AW-262-11 - 9 Kingsway - OBJECTION - 12-12-2011

This application, AW/262/11 is, effectively, a re-submission of AW/155/11 for one has to study the two Site Plans closely to detect that the odd 12" (305mm) has been extended to the lawn in the centre and a small bed at the side of the house while slightly curving the eastern boundary edge. **Essentially, the design is the same and no attempt has been made to amend the layout which, from the public viewpoint in the service access road, remains a mass of block paving with scant views of small vegetated areas.**

SITE PLAN - 1/500

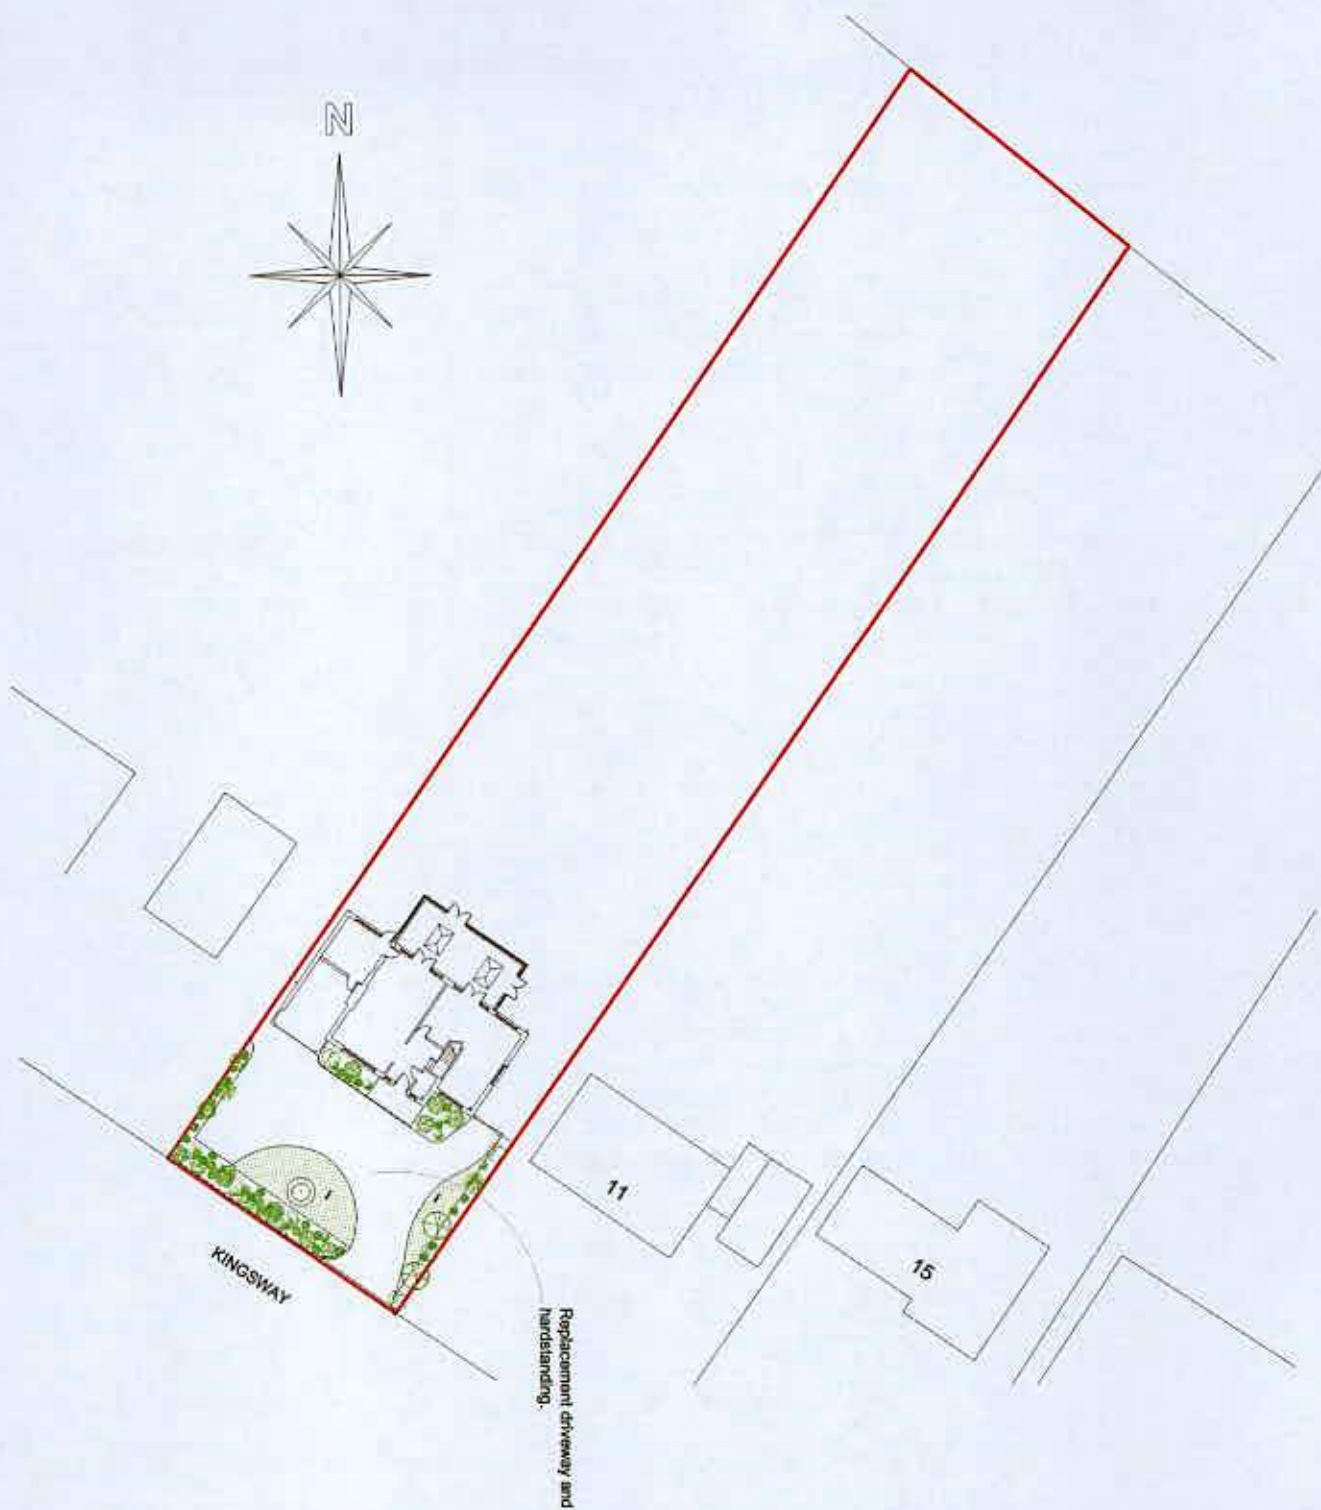
No matter what the cost -- and it will not be great -- I still contend that the proper layout of this driveway is to have it on the west (left on the photograph attached) side of the house with a short turning area in front of the house. **The potential for then creating a garden worthy of the house and the newly designated Craigweil House Conservation Area is enormous with paving transformed from the current 'NCP' parking lot into a magnificent vision of unadulterated beauty to the benefit of all, whilst serving to preserve or enhance the established characteristics of Craigweil House CA.**

Whatever the decision of the Planning Officer or the Development Control Committee – whoever is the Decision Maker – it is essential that serious thought be given to preventing the existing block paving design and layout being marginally altered by taking down the front garden wall at the western (garage) end and maintaining the existing eastern access for this, then, would create an 'in-and-out' driveway and a precedent for this to be replicated further down Kingsway where the highly valued wide grassed and treed verges are to be found. These were highly praised by the English Heritage Inspector and are a significant feature in the Conservation Area Description Statement.

I make no implication as to the ultimate intentions of the applicant in this respect but the existing layout enables the removal of the 28" (700mm) high front wall by Permitted Development Rights as things stand right now.

If a driveway entrance is to be required from the west, in front of the garage, then I ask that directions be given that the eastern vehicular entrance be close off.

In order to prevent any future development of the in and out driveway, I also ask that a condition be added to any consent withdrawing Permitted Development Rights for any demolition, partial demolition or modification of the front (south) garden wall.

I ask that this application be refused and that a landscape design of a GARDEN and not a PARKING AREA be required to be submitted by the applicant for this application is no more than a very slight modification of that refused.

At the moment all we have is tiny borders surrounding a mass of block paving. What is appropriate at Craigweil House Conservation Area is that a driveway be facilitated through an attractively and professionally designed front garden.
